Subject: RE: Saltbox Unit 9 site Planning Condition 12 response Surface water

Paul Cann
Principal Drainage Engineer
Engineering Services

Please see attached revised drainage proposals for the Saltbox Unit 9 project for the release of planning condition 12. The proposals have been amended to lift the drainage system up to achieve a gravity discharge as per the original strategy. We have included on the drainage plan drawing pipe sizes, gradients, cover and invert levels also added to the drawing as requested.

PROJECT ORIGINATOR ZONE LEVEL TYPE ROLE NO	Revision
114378-CAL-XX-XX-DR-D-0201	C

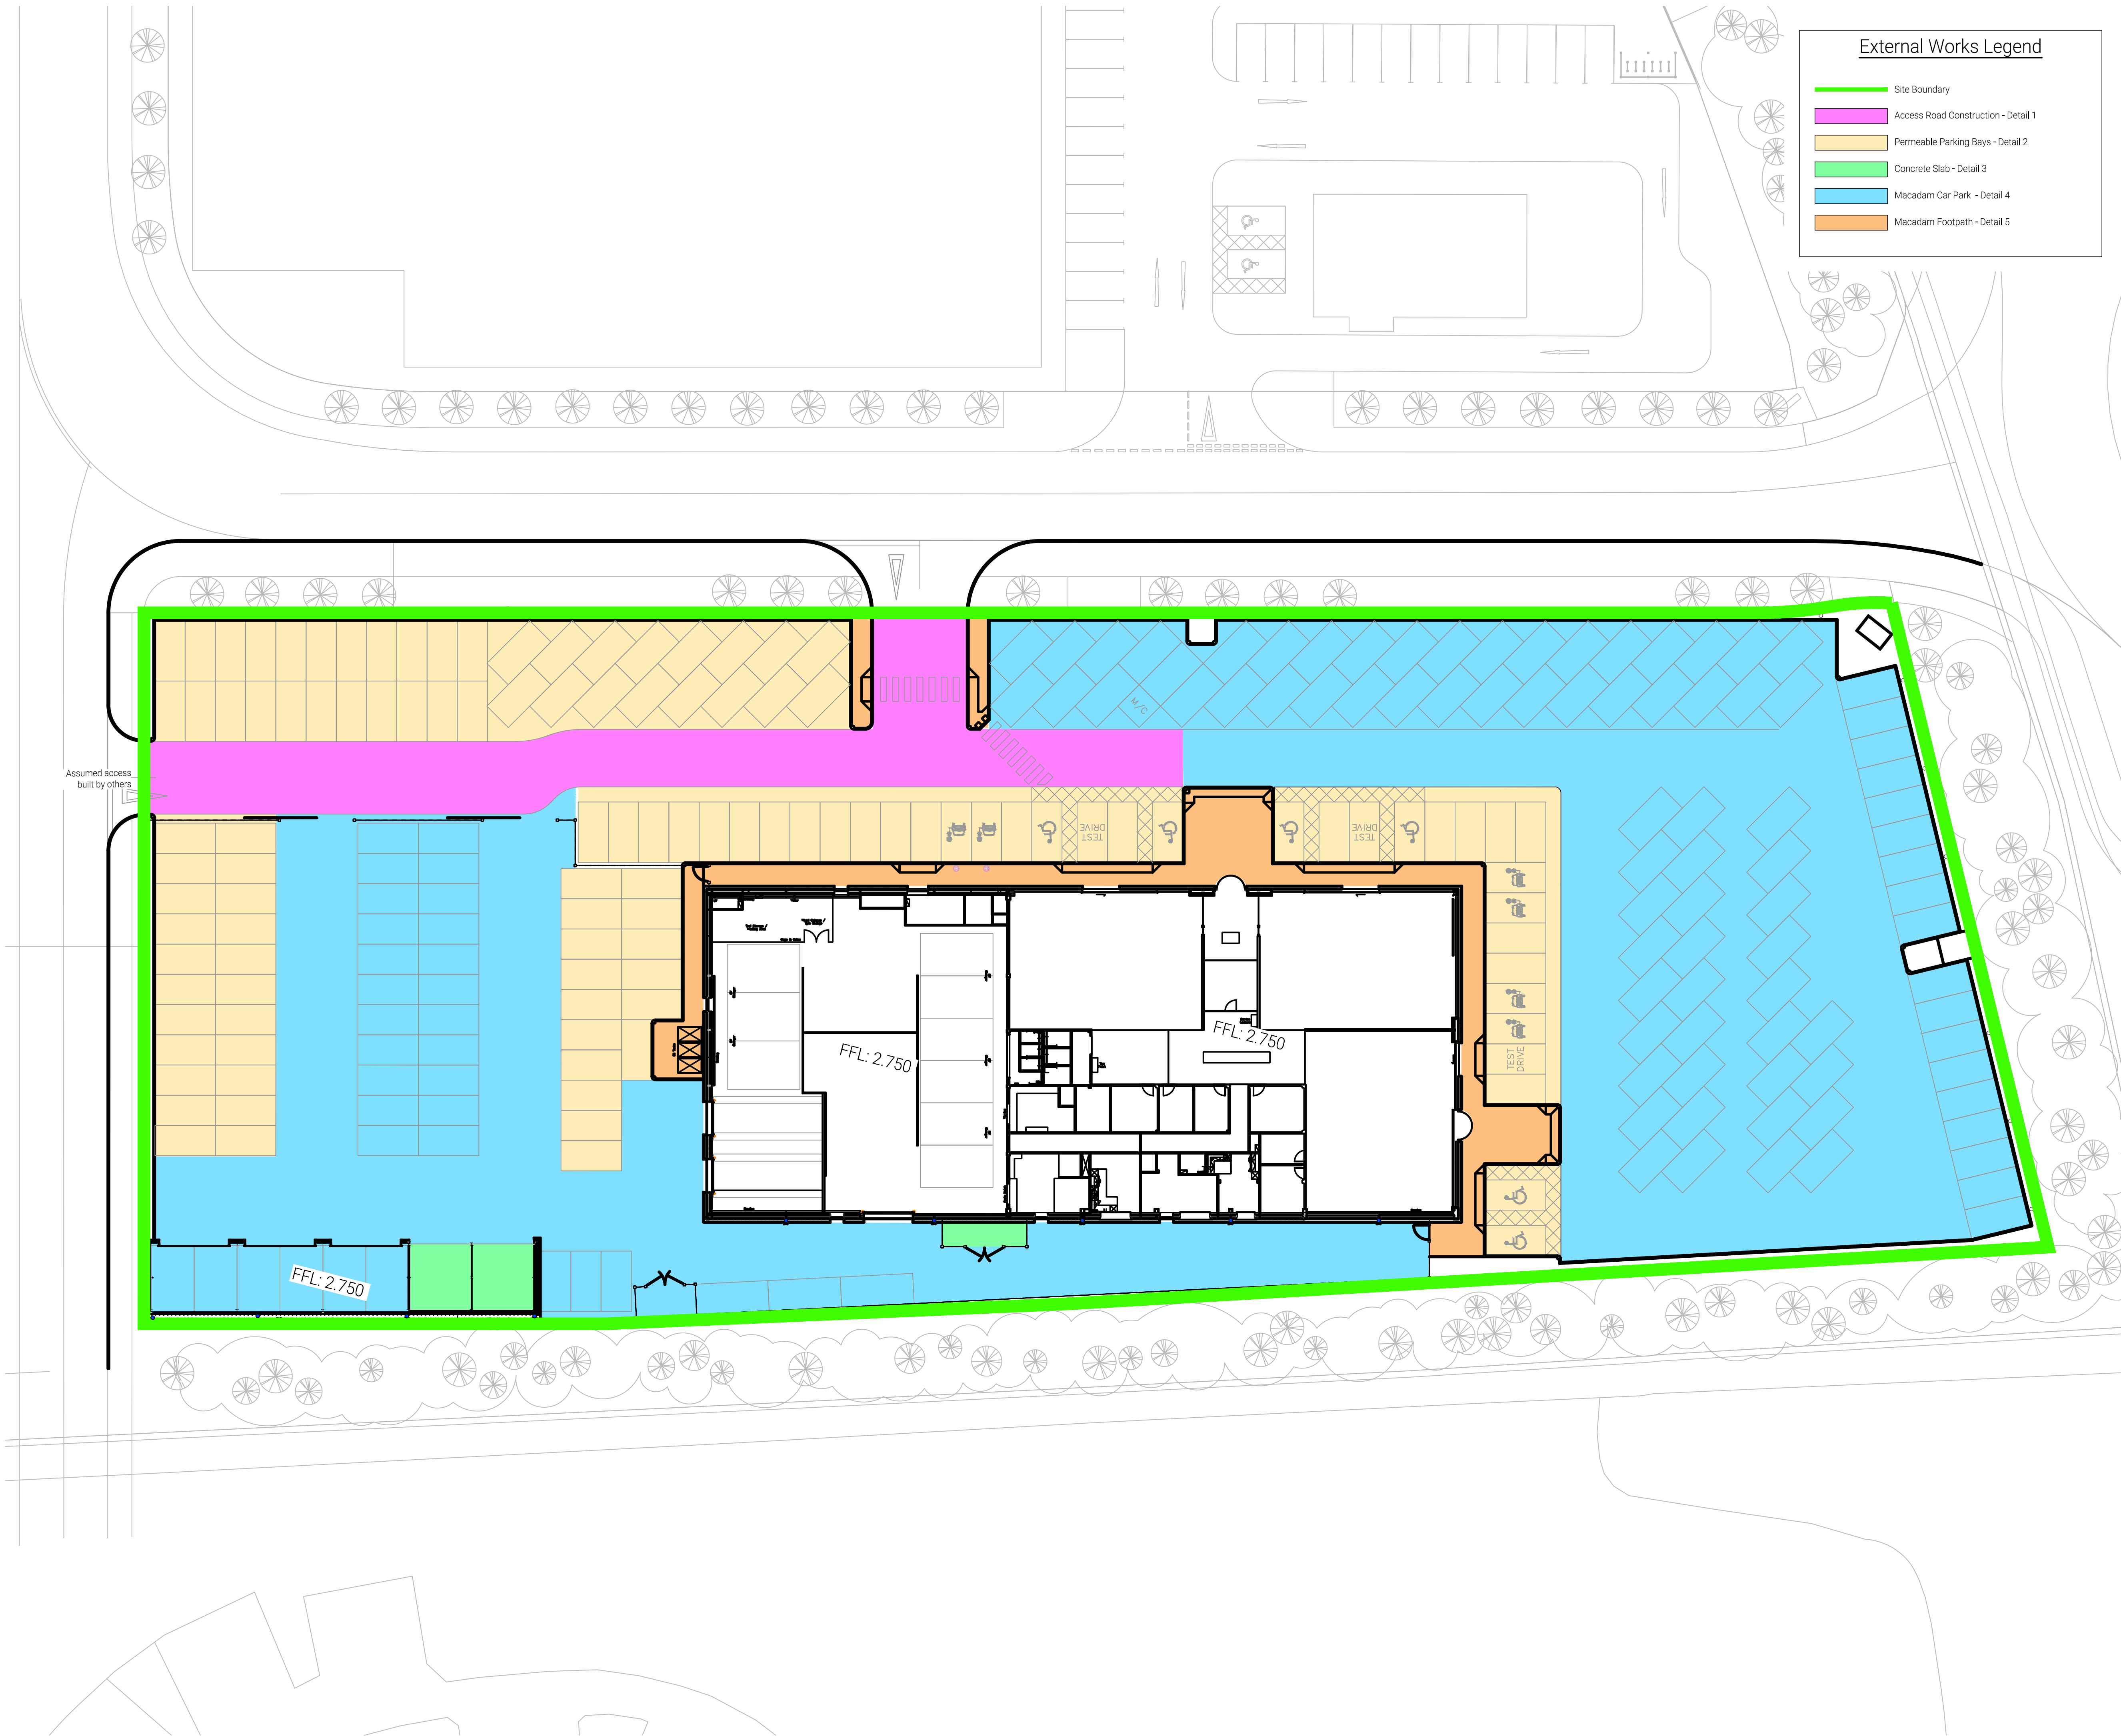
1. **Specify all inlet invert levels to attenuation tank.** Invert levels to all attenuation tank inlets shown. Include connection at S22 and 375mm pipe inlet levels. Slacken gradients on pipelines 8.000 to 8.003 to avoid an invert to invert connection into the tank. i.e. lay 150mm at 1/150, 225mm at 1/225, 300mm at 1/300, if possible. Connection at S22 and 375 inlet levels added. Gradients slackened on 8.000 to 8.003 to the gradients suggested above. ok

2. **Pipeline 4.000 (now 7.000) – increase pipe diameter to 150mm and lay at 1/150 gradient. This will raise connection level to manhole S11.** Permeable paving connections are to remain as 100mm diameter at 1:100 gradient to contain short term extreme rainfall. If the hydraulic model is relying on flows from the permeable pavement being restricted then fine, however, I am concerned that pipeline 7.000 will be discharging approx. 100mm above the invert of the 375mm pipe so not ideal. You could consider laying the 100mm pipe at 1 in 150 as siltation will not be an issue due to flows passing through a permeable pavement and assuming the model will still work ok. Or you consider a fin drain outlet from the permeable paving which would allow a higher outlet level which will also allow a higher connection. Pipeline 7.000 amended to 100mm dia. 1/150 grad to lift inlet into S11. ok

3. **Pipelines 3.000, 3.001, 3.002 – increase to 150mm diameter with 1/150 gradient to raise connection level to manhole S8.** Permeable paving connections are to remain as 100mm diameter at 1:100 gradient to contain short term extreme rainfall. This is not draining a permeable pavement so I can't see a reason why it cannot be adjusted. Pipelines 3.000 to 3.002 amended to 150mm dia. 1/150 as requested. ok

4. **Manhole S7 – two incoming connections with no obvious purpose?** This is a small section of perforated pipe within a narrow gravel margin around the building line. It is anticipated that barely any flow will enter these pipes. Ok but please adjust note on plan to refer to manhole S7 as opposed to S2. Note amended to refer to S7. ok

5. **Road gullies in southwest corner – specify diameters and gradients and ensure all connect to chambers on the attenuation tank.** These are rainwater pipes from the vehicle washdown area. I have added diameters and gradients to the plan as requested. Ok but slacken all RWP + channel outlet gradients (i.e. 1/100) so connections into the tank are as high as possible. RWPs from washdown area have been slackened to 1/100 as requested. ok

6. **Gully connection into manhole S22 – reconfigure to improve angle of connection into manhole.** We have added a 45-degree bend for straight connection into the attenuation tank. Layout plan not amended +

7. **Pipeline 1.004 – perhaps upgrade to 300mm diameter laid at say 1/300 in order to provide some resilience with this important pipe and its invert-to-invert connection with the 450mm pipe.** The flow control for this pipe is situated upstream and therefore only a max flow of 2.3l/s will be flowing through. The capacity of the pipe currently specified will easily facilitate this flow rate as the modelling output provided demonstrates. My comment does not relate to pipe flow capacity but the fact that you are connecting a 150mm pipe at invert to invert with a 450mm pipe and therefore more risk of the pipe being obstructed in the future due to any potential issues downstream. It is also a compromise of allowing an invert to invert connection. It would also help facilitate flows from an emergency overflow for exceedance, if one were required/permitted in the future. Pipe downstream of Hydrobrake amended to 300mm diameter at 1/300 as requested. ok

1. Adjust any pipe gradients as necessary where pipelines involve catchpits ie. no need to allow for gradient through the chamber (inlet and outlet levels can be the same level). This will provide some slight help with in trying to achieve soffit to soffit connections where possible.

2. Specify gully lateral gradients/outlet & inlet levels. ie. those that connect to manholes S1 and S3. Laterals to be 150mm diameter laid at 1/150 to keep connection levels as high as possible.

3. Manhole S3 – error in invert level on layout plan ie. 1.722/1.772.
4. Manhole S8 is missing connections on manhole level schedule.
5. Incoming connection into manhole S8 from permeable paving (no pipe number specified) – to be 150mm diameter at 1/150 gradient to keep connection as high as possible. Incorporate manhole at end of perforated pipe to accommodate the necessary bend.

6. Pipeline 1.002 – correct gradient to allow for bypass separator levels. Adjust levels of separator ie. outlet is lower than invert of manhole S11 downstream.

7. Specify all inlet invert levels to attenuation tank.
8. Manholes S6 and S9 – ensure no bends outside of manholes.
9. Pipeline 4.000 – increase pipe diameter to 150mm and lay at 1/150 gradient. This will raise connection level to manhole S11.

10. Pipelines 3.000, 3.001, 3.002 – increase to 150mm diameter with 1/150 gradient to raise connection level to manhole S8.
11. Manhole S7 – two incoming connections with no obvious purpose?

12. Manhole S14 – one incoming connection with no obvious purpose?
13. Manhole S14 – cant see why the system can't be altered to achieve a soffit to soffit connection.

14. Pipelines 2.000 & 5.000 – increase to 150mm diameter assuming upstream perforated pipe is also 150mm.

15. Road gullies in south west corner – specify diameters and gradients and ensure all connect to chambers on the attenuation tank.
16. Gully connection into manhole S22 – reconfigure to improve angle of connection into manhole.

17. Pipeline 1.004 – perhaps upgrade to 300mm diameter laid at say 1/300 in order to provide some resilience with this important pipe and its invert to invert connection with the 450mm pipe.

18. Pipelines 7.000 & 8.000 – upgrade to 150mm diameter. Provide detail of how the connections will be made to the attenuation tank.
19. Add note – all pipes to be laid soffit to soffit unless otherwise specified.

20. Upstream ends of perforated pipes beneath permeable paving to be capped – add note to construction detail.
21. Specify invert levels of head of all perforated pipes (and gradients) on layout plan.

22. Please confirm that the external levels layout drawing remains unchanged.
23. Washdown area – has surface water run off into this area been minimised ie. levels indicate that some of the car park falls towards this area.

24. Remove pumping station notes from drainage layout sheets 1 & 2.
25. All connections not made to manholes to be made using oblique 45 degree junctions (add note).
